Demolition of existing dwelling (No. 32) & erection of 4 No. 4 bed dwellings, alterations to existing dwelling (No. 34A) with alterations to two existing accesses to form a single point of access. This application may affect the Character & Appearance of the Ferring Conservation Area.

32 & 34A Sea Lane Ferring

Thank you for your internet representation made on 18th December 2017 which has been recorded as '**an objection**' with the comments as follows:

DRAWING TITLE
Proposed Site Plan, Location Plan
and elevation from south

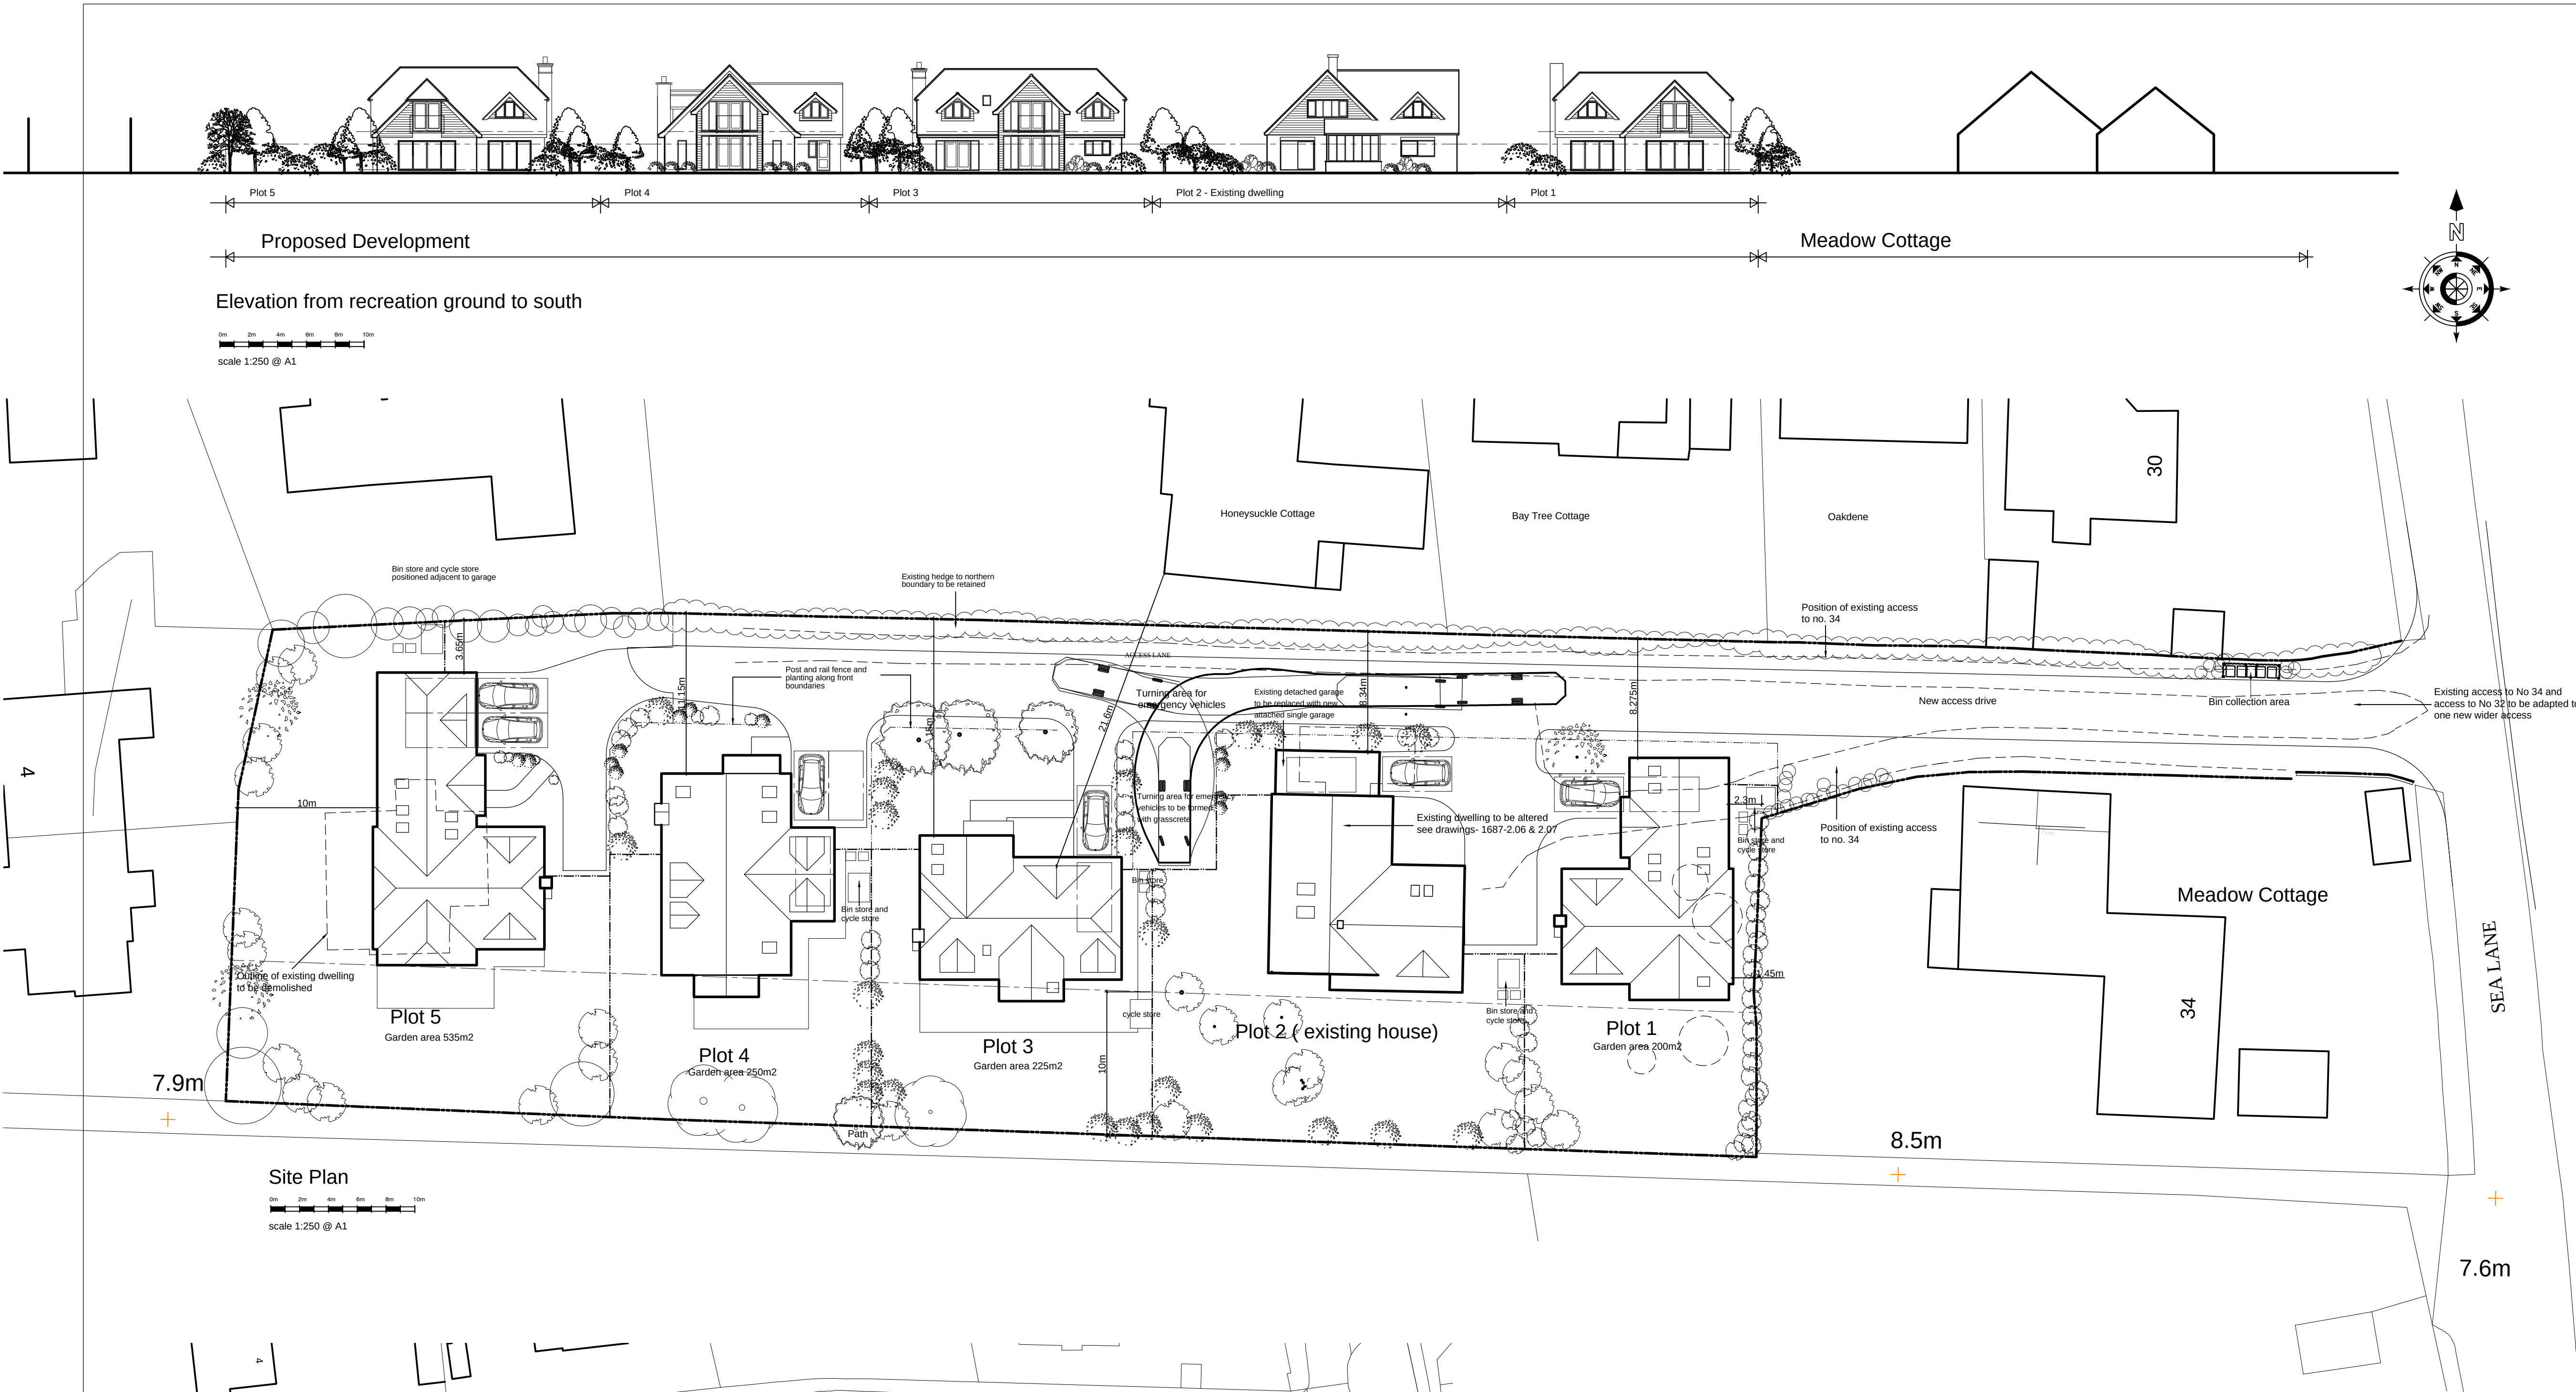
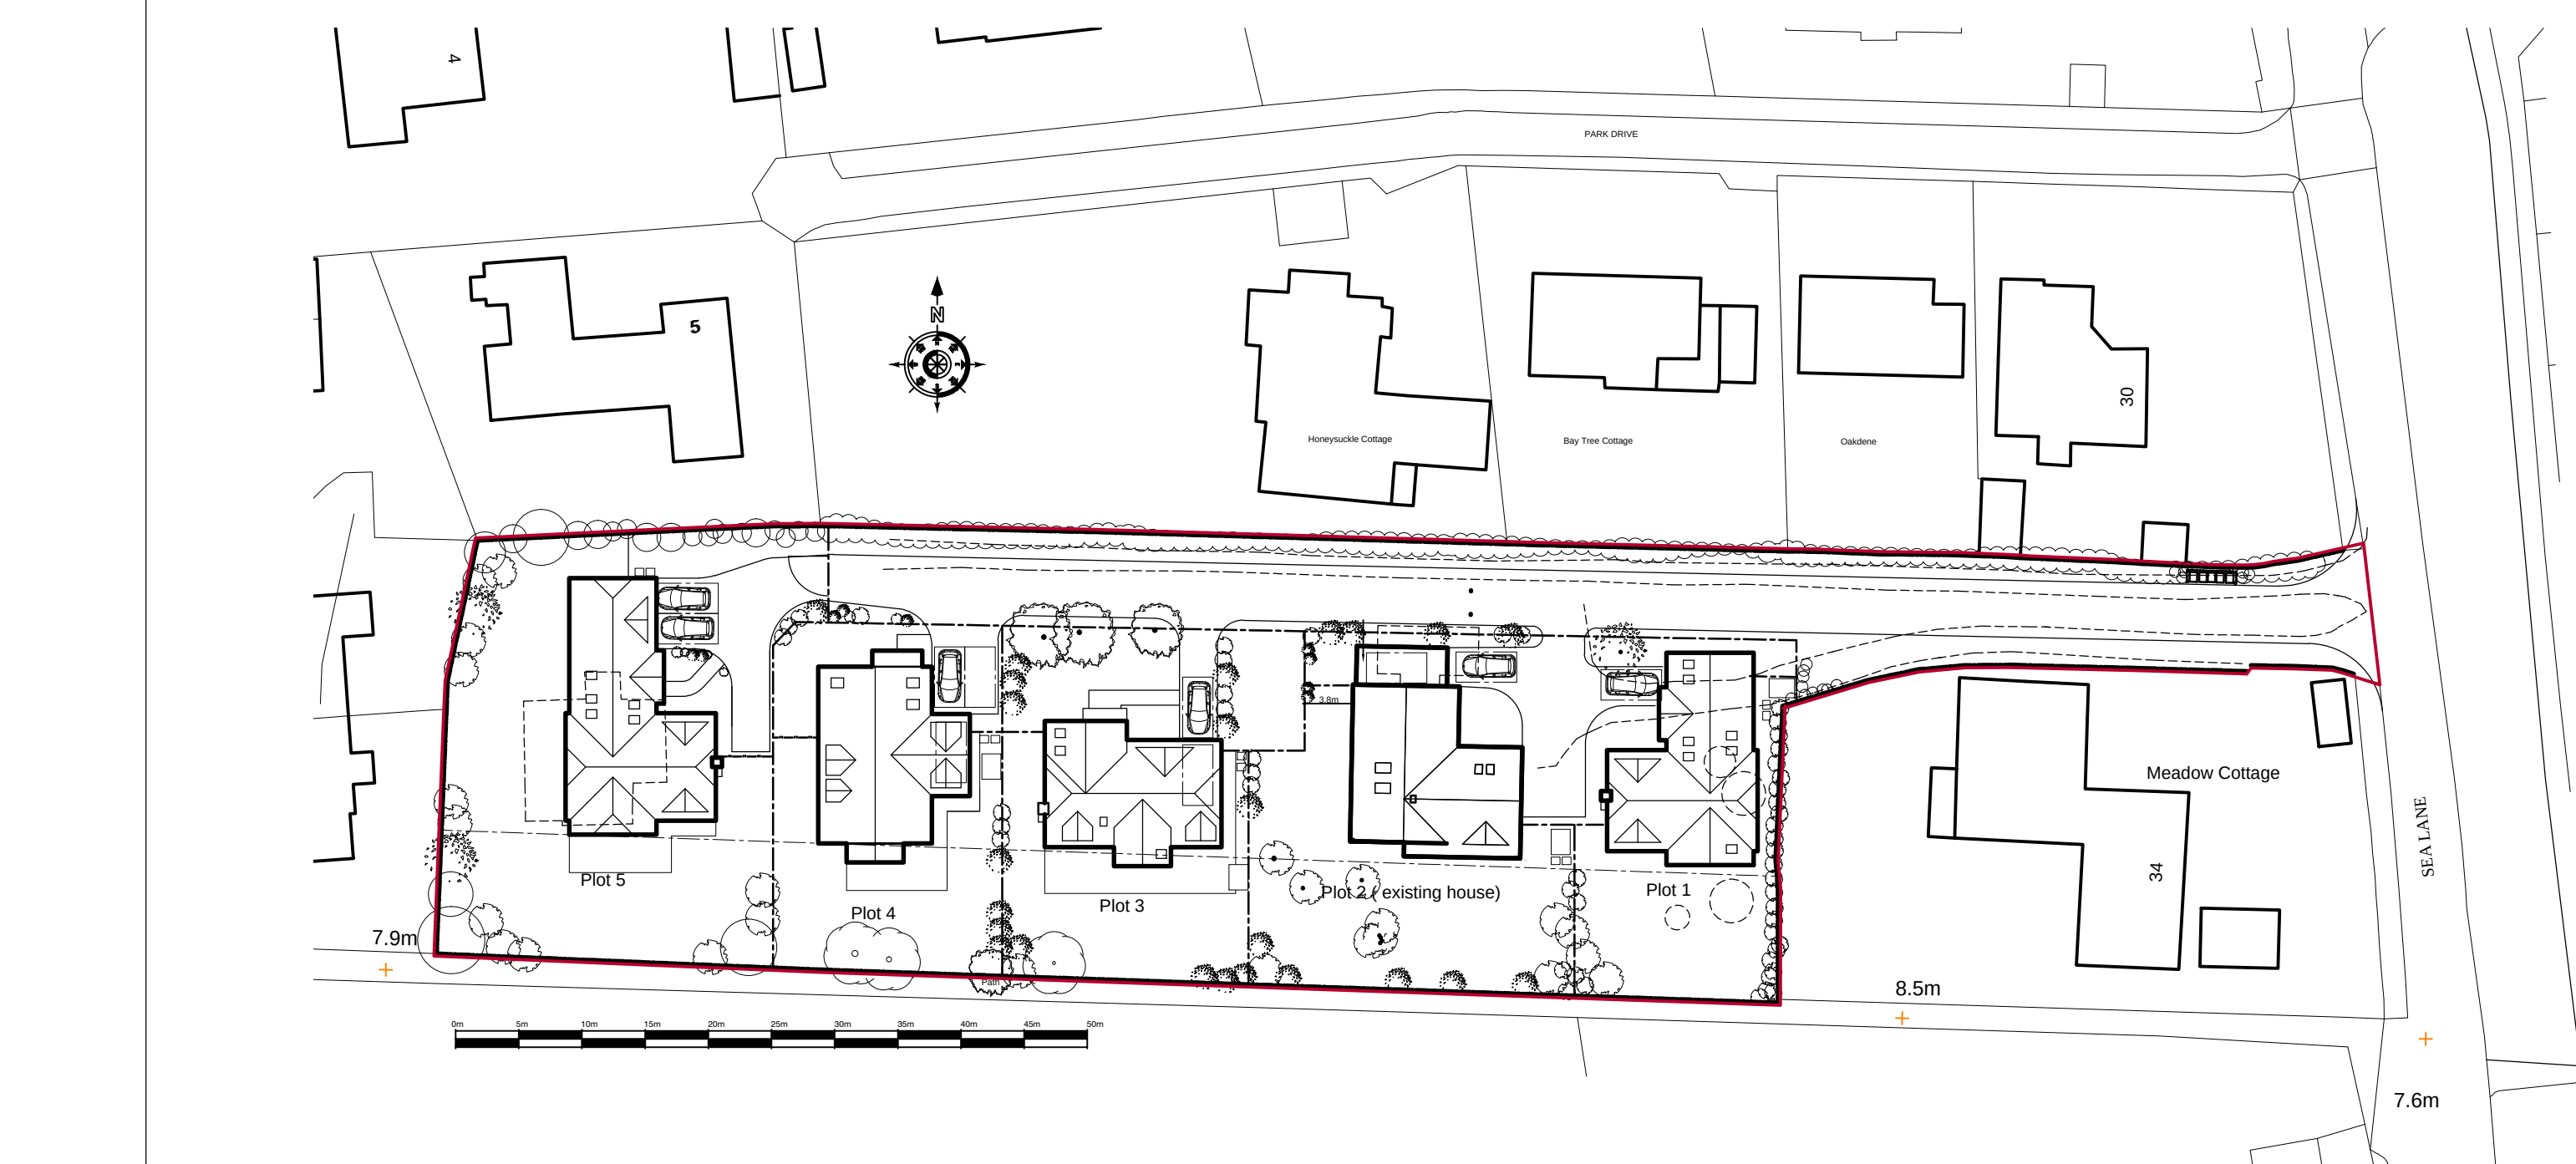
Looking at the site plan and knowing the surroundings, the 5 detached houses proposed with virtually no separation or garden land is way over the top in development for the site and I object therefore.
